Please ask for: Ms Iqraa Malik
Email: iqraa.malik@terraquest.co.uk
Telephone: 0121 234 1390
Our Ref: FG/178/21/HH
Your Ref:
Date: 5th October 2021

Application for Planning Permission for Works or Extension to a Dwelling

Development: Single storey front extension, two storey side extension and section of rear dormer
Location: 12 Colindale Road North Ferring BN12 5LB

BLOCK PLAN 1:500

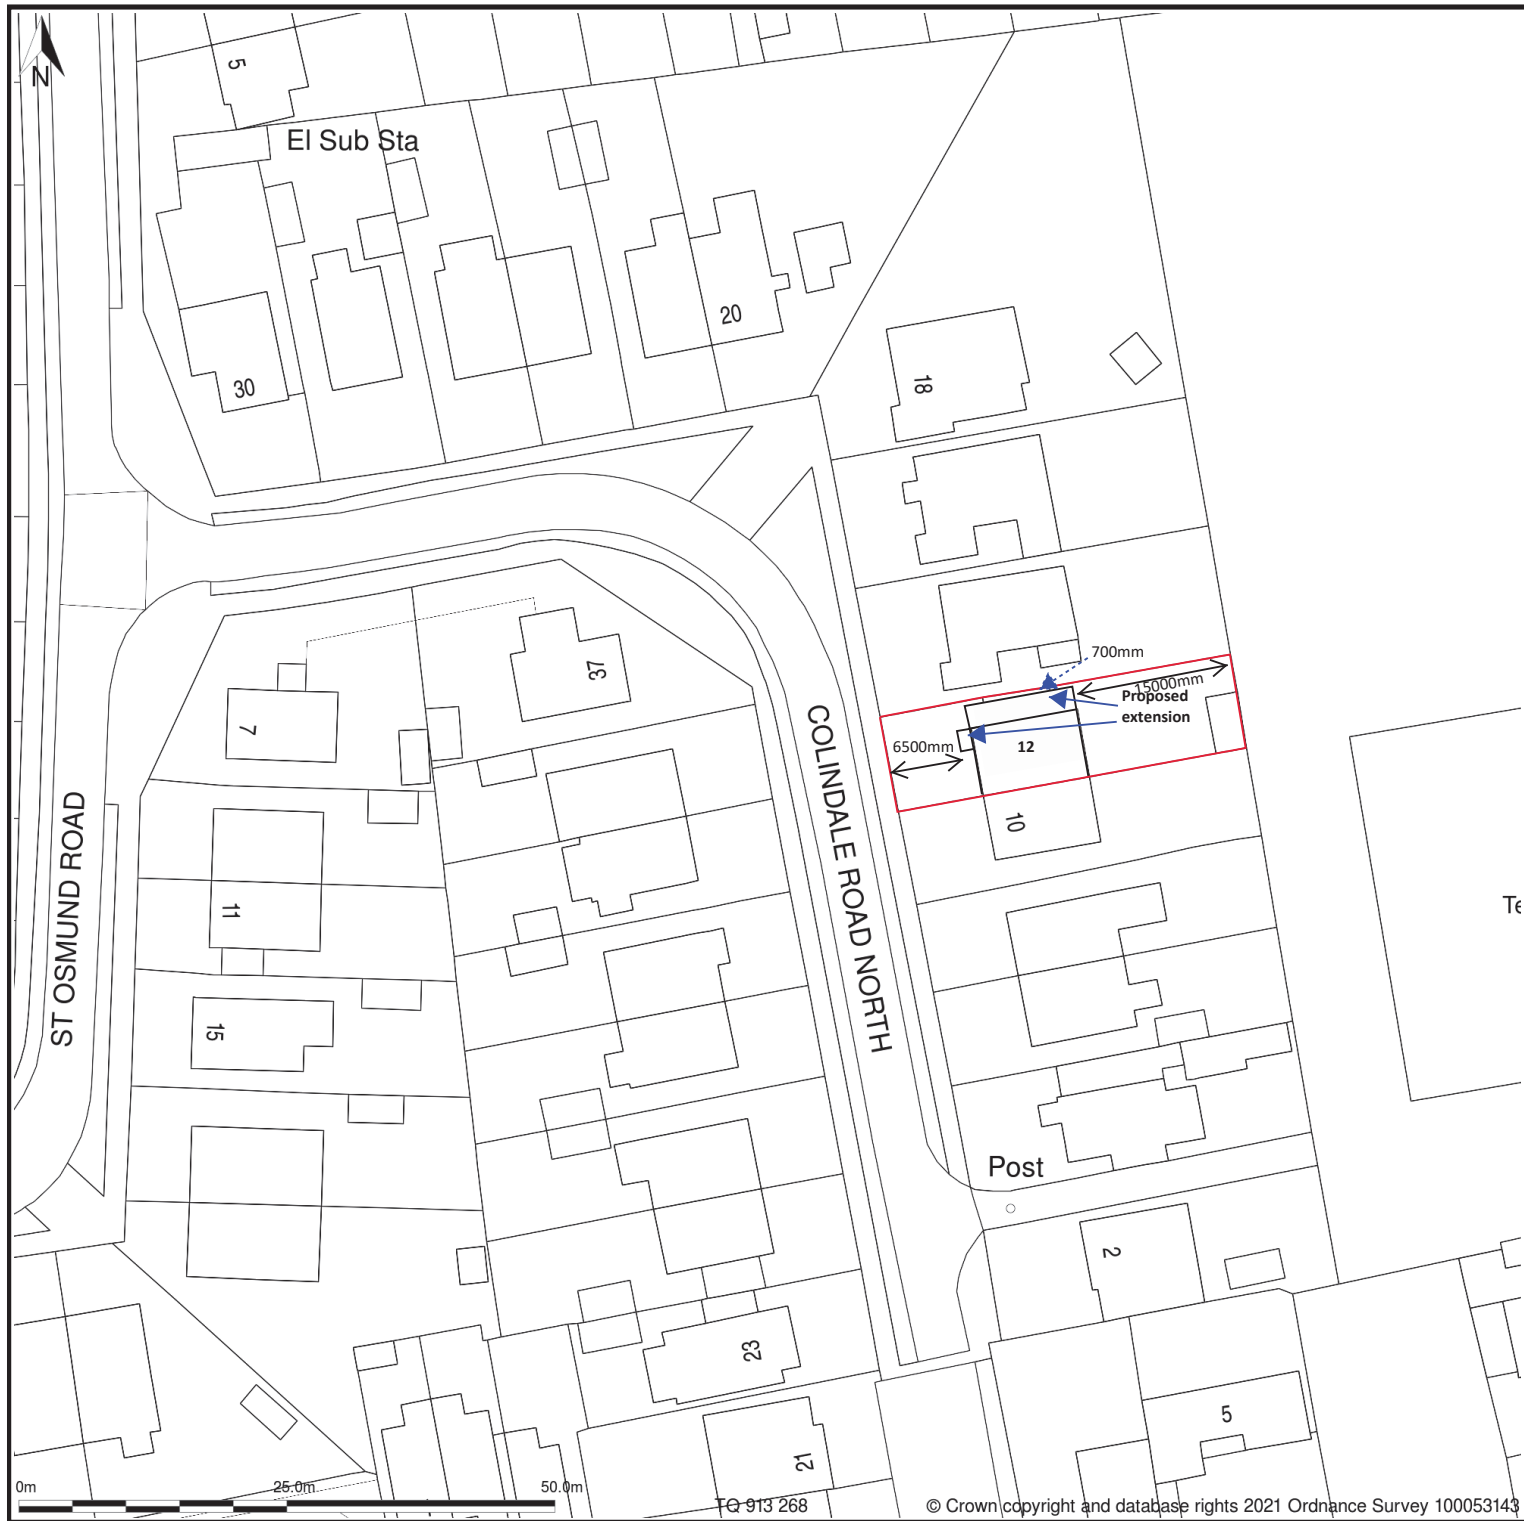
Block Plan

You are required to have dimensions from the proposed extension(s) to all site boundaries. Please amend.

EXISTING FRONT ELEVATION 1:100

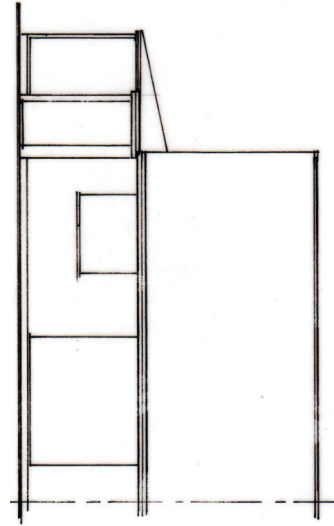
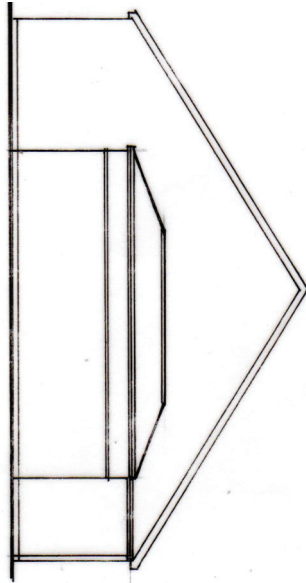
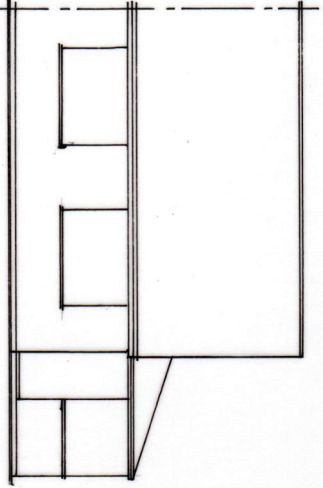
Elevations

Please submit existing elevations at a scale of 1:50 or 1:100. Further details can be found in the Validation Requirements List.
